Harnett County
420 McKinney Pkwy
LILLINGTON, NC 27546
Phone:
Fax:

SUBJECT: **SFD2504-0099**
SINGLE FAMILY DWELLING

Here are the results of all Inspections located at **22 CELTIC LN:**

DRAWING TITLE: **FRONT & REAR ELEVATIONS**

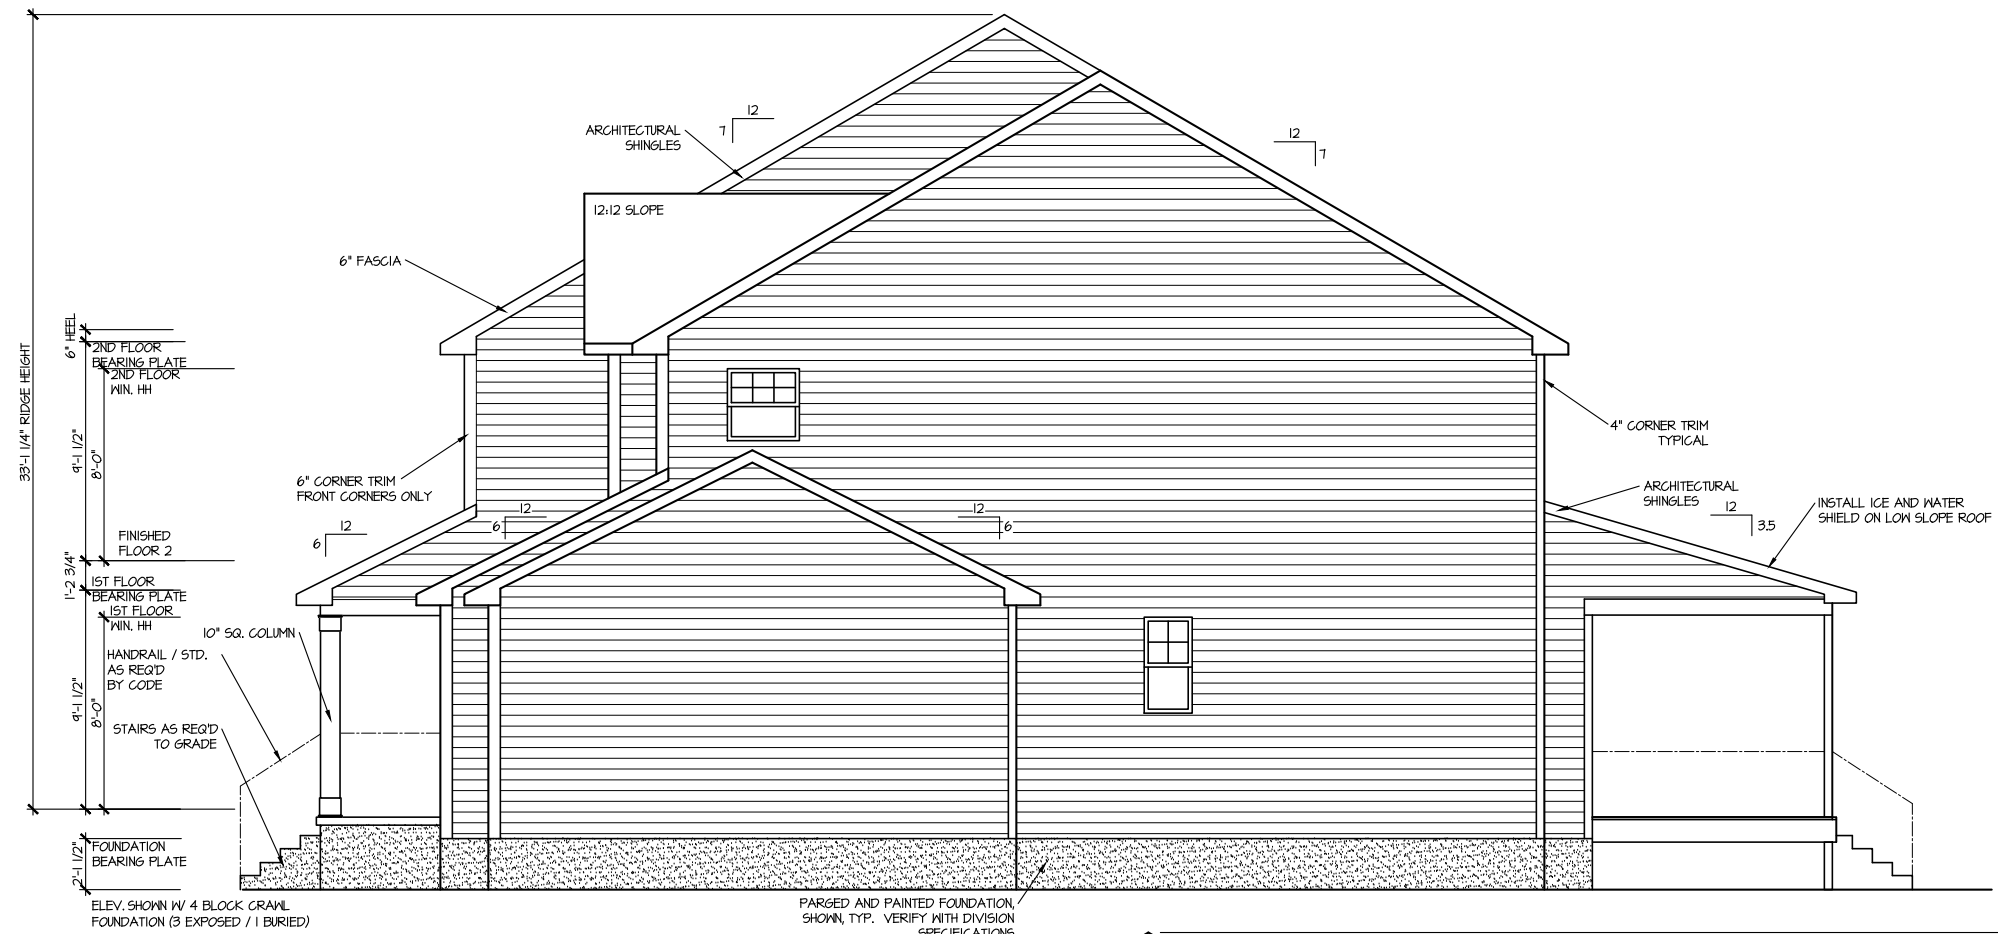
Door locked, unable to access home. Front steps do not meet code.

Step height cannot exceed 8.25 on front porch steps.
